**Planning Act 2008 – Section 88 and the Infrastructure Planning (Examination Procedure) Rules 2010 – Deadline 5: Post Hearing submission of oral case for Issue Specific Hearing 6 Coastal Geomorphology.**

**Application by NNB Generation Company (SZC) Limited for an Order Granting Development Consent for the Sizewell C Project**

## Appendix A: Environment Agency summary of oral case for ISH6: Coastal Processes

DRAWING TITLE:
 PERMANENT COASTAL DEFENCE FEATURE
 TYPICAL SECTIONS

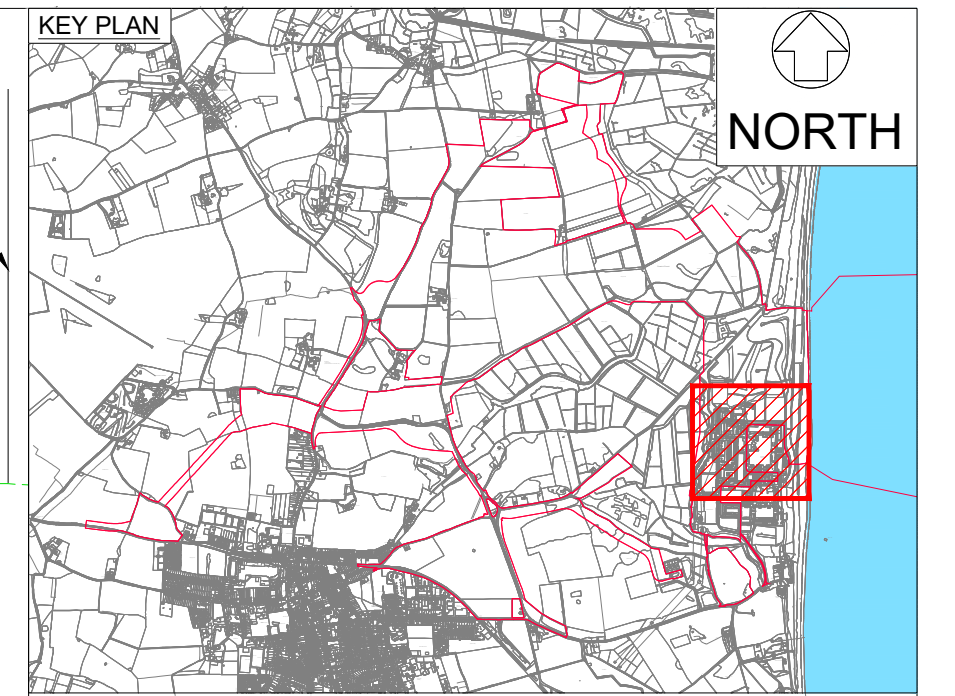
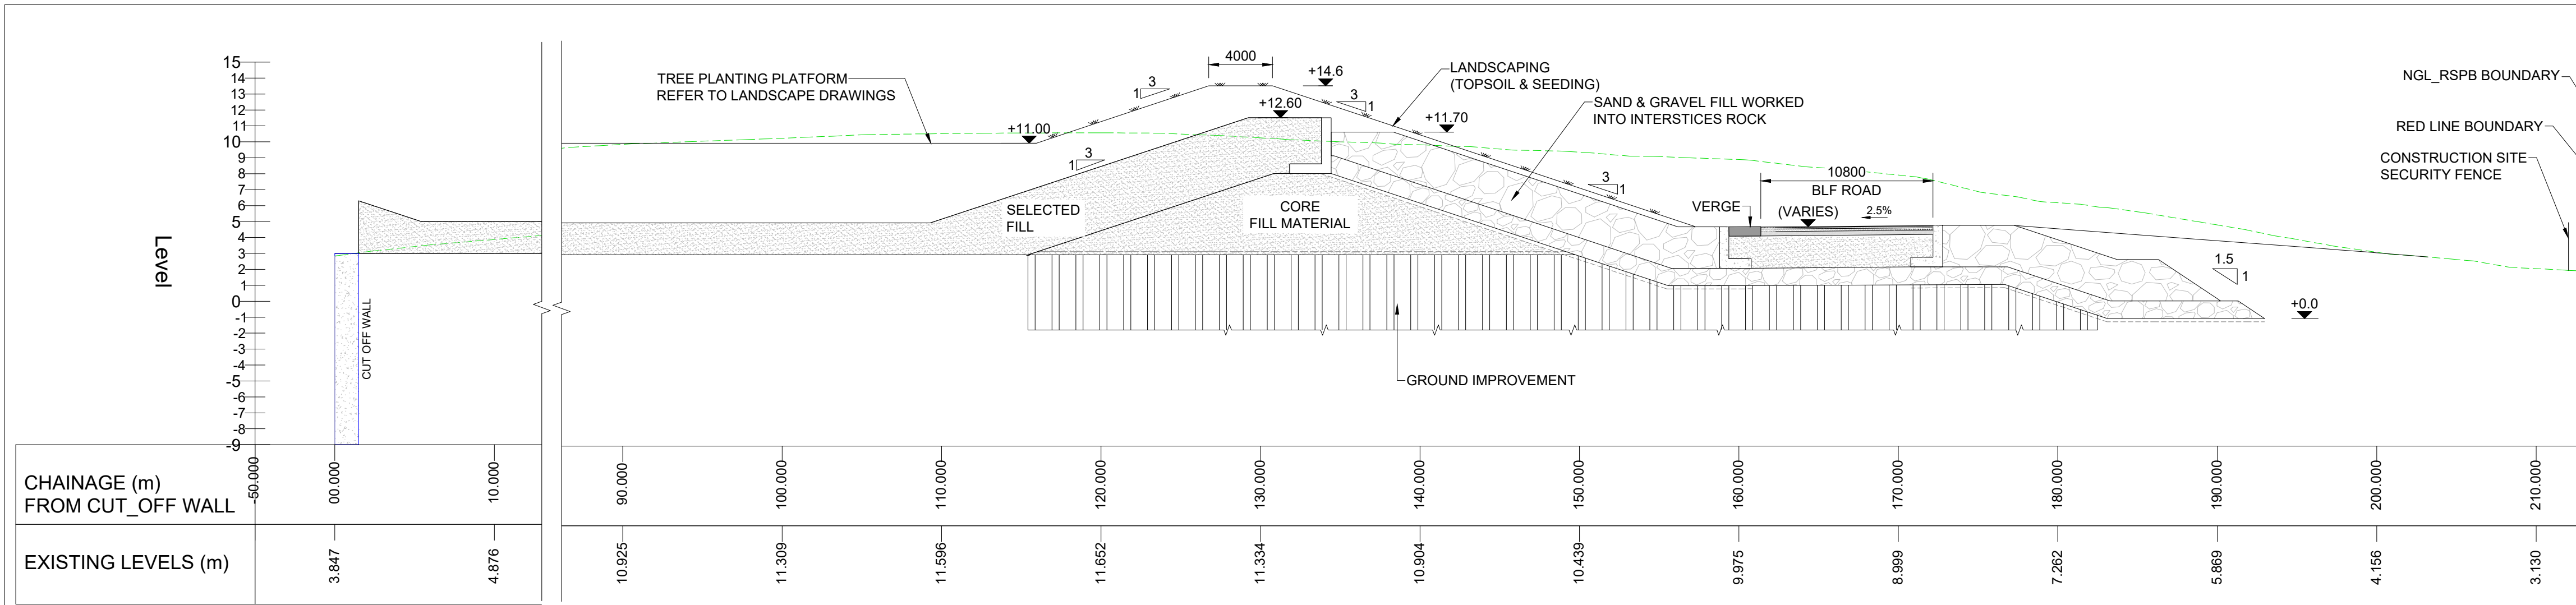
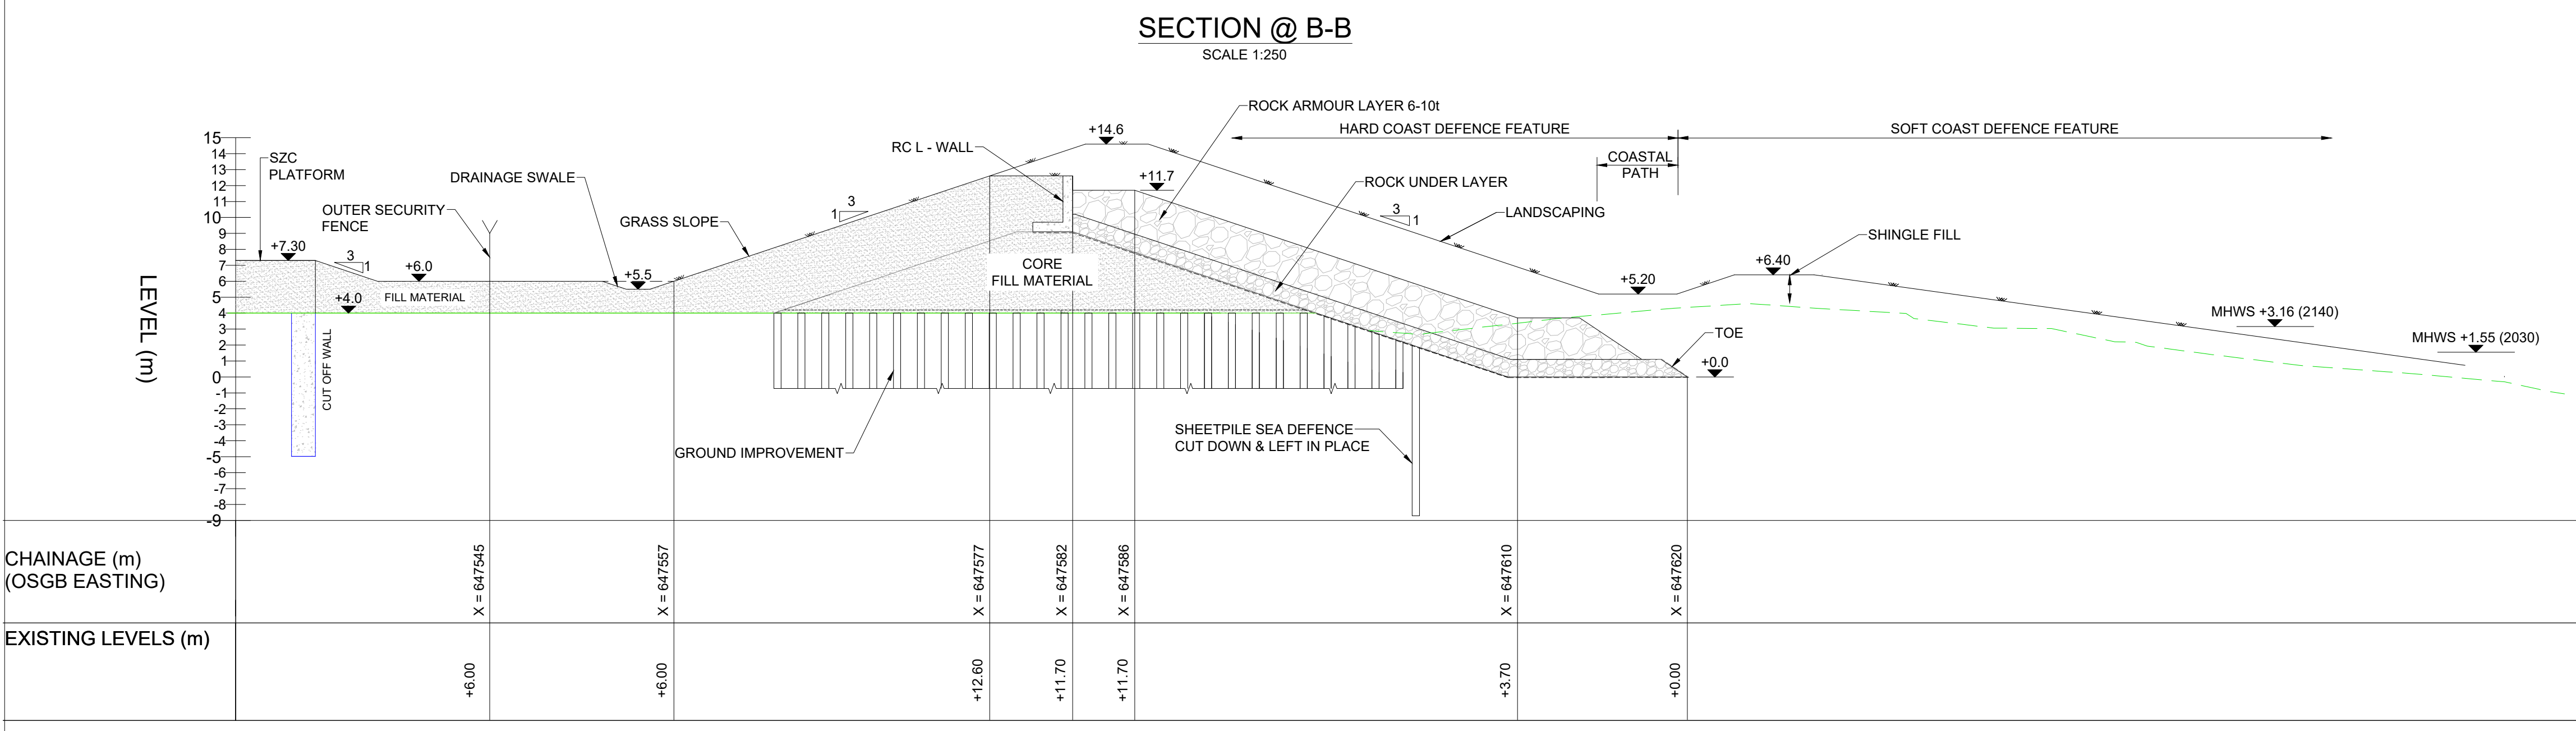
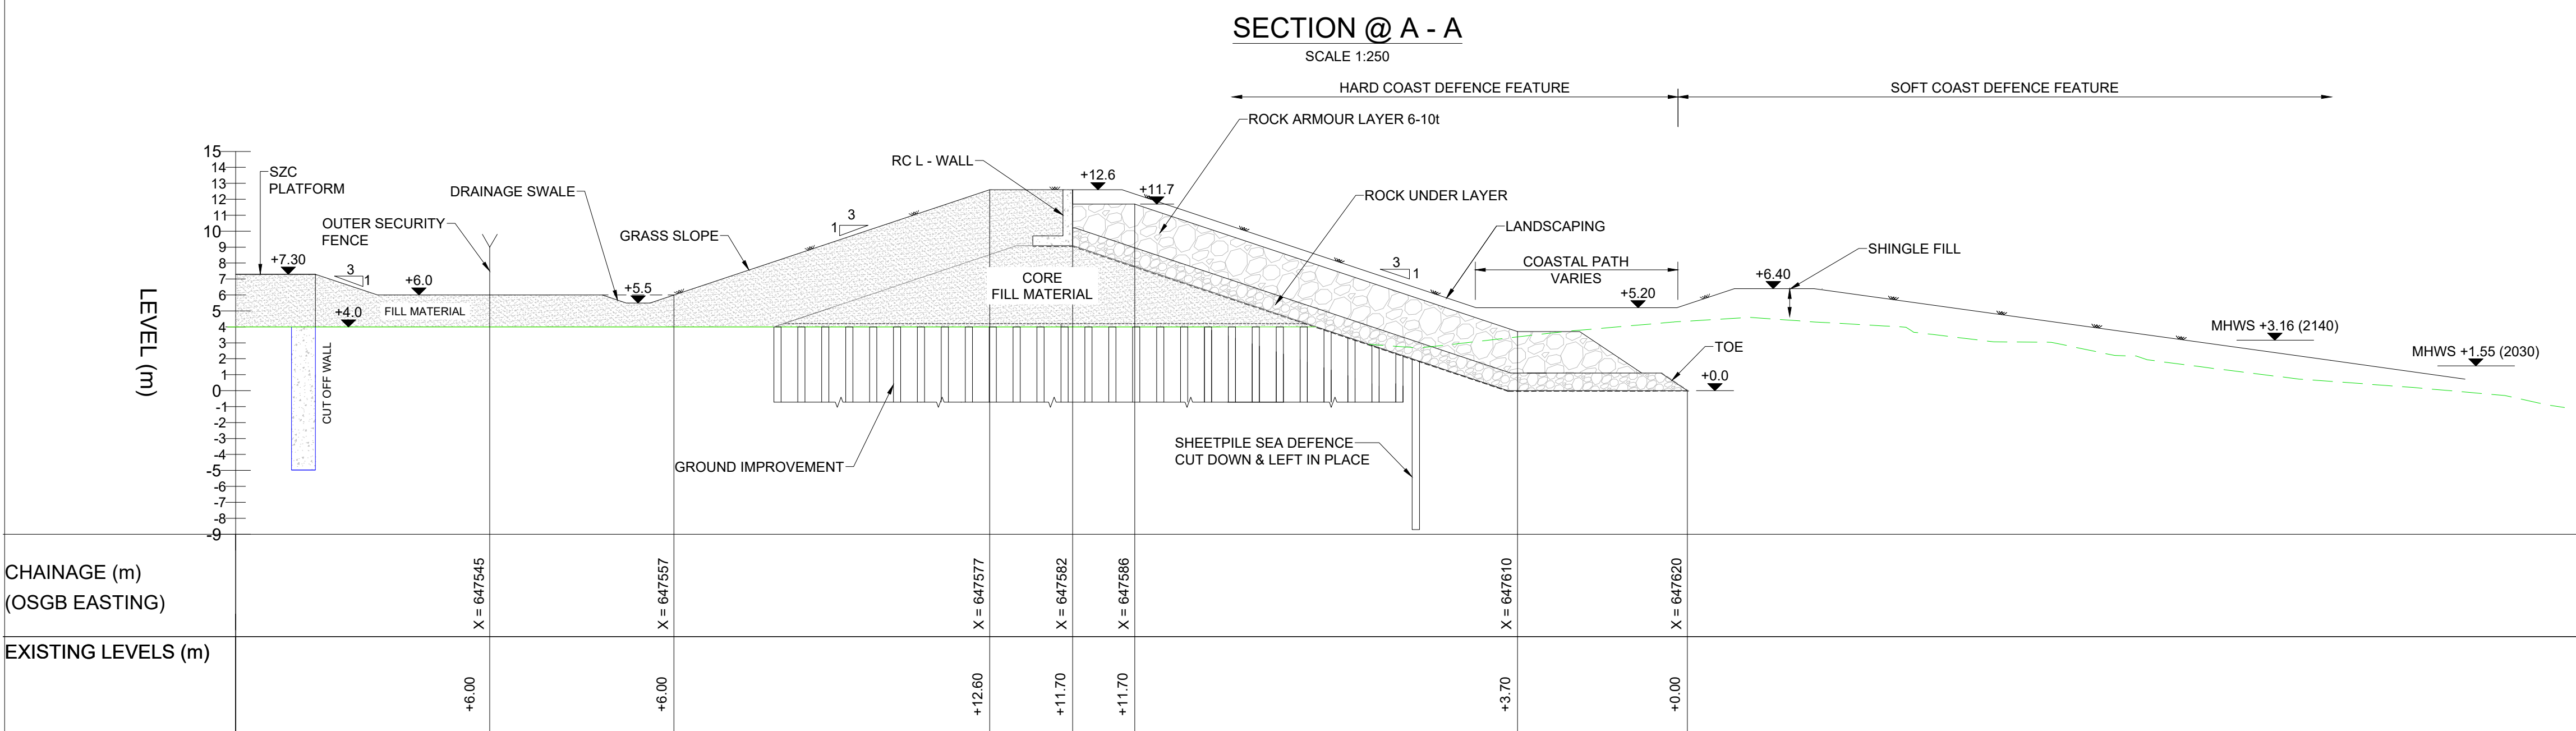
(b) If not, what additional information would be required?	We are awaiting further modelling up to site decommissioning and detailed designs of SCDF & HCDF. Remain concerned that detailed design process could mean need for seaward advancement of HCDF toe.

(g) Cumulative impacts.	With regards to the BLF, HCDF and SCDF, we cannot scrutinise the cumulative impacts of the project at this stage because outstanding modelling – notably of the adapted HCDF design and morphodynamics of the SCDF beyond 2099 – are required to inform our position. With regards to the in combination impact with other projects such as EA 1 and 2 wind farms, again, we cannot make an informed judgement until the all modelling has been completed and designs finalised.
The adequacy of the proposed	(a) The scope for the HCDF to undergo design adaptation to	Design changes that move the HCDF seaward could affect our position, but we cannot comment further until we have seen these designs.
